**Advice on Amendment Report and Submissions Report – State Significant Development
Proposal: Moolarben OC3 Extension Project**

Major Project reference: SSD-33083358

In preparing this advice Heritage NSW has reviewed the following documents:

ATTACHMENT 7 – ABORIGINAL HERITAGE SURVEY COVERAGE

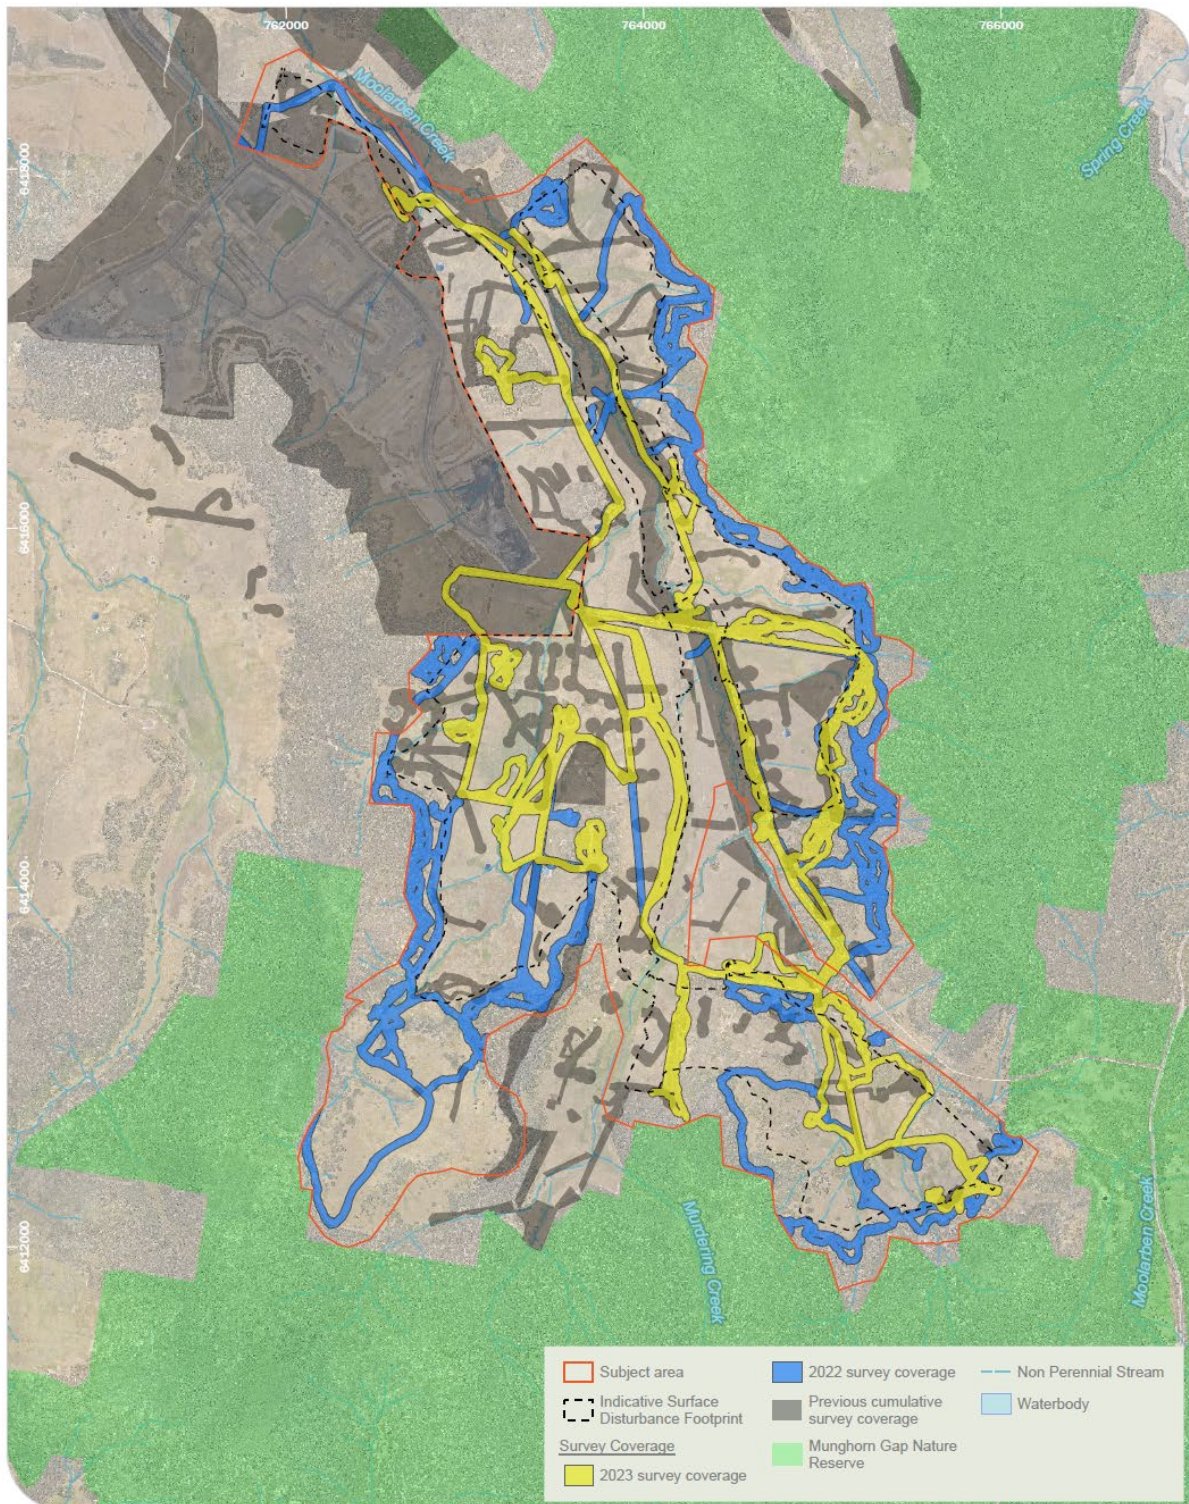
1. The survey mapping for the 2023 surveys shows large areas of overlap with the existing survey efforts. Please clarify whether 2023 surveys targeted areas previously unsurveyed or if there were efforts to resurvey existing areas. Where those overlapping areas were not subject to resurvey, please remove these from calculations of additional survey coverage and update the relevant mapping, tables, and text to reflect the correct extent of the survey coverage.

2. Calculations of survey extent and effective survey coverage must separate the subject area and disturbance footprint. As the project footprint has undergone several changes and reductions, large sections of the surveyed area are now outside of the disturbance footprint and the current survey calculations may misrepresent coverage in the areas to be directly impacted from mining activities.
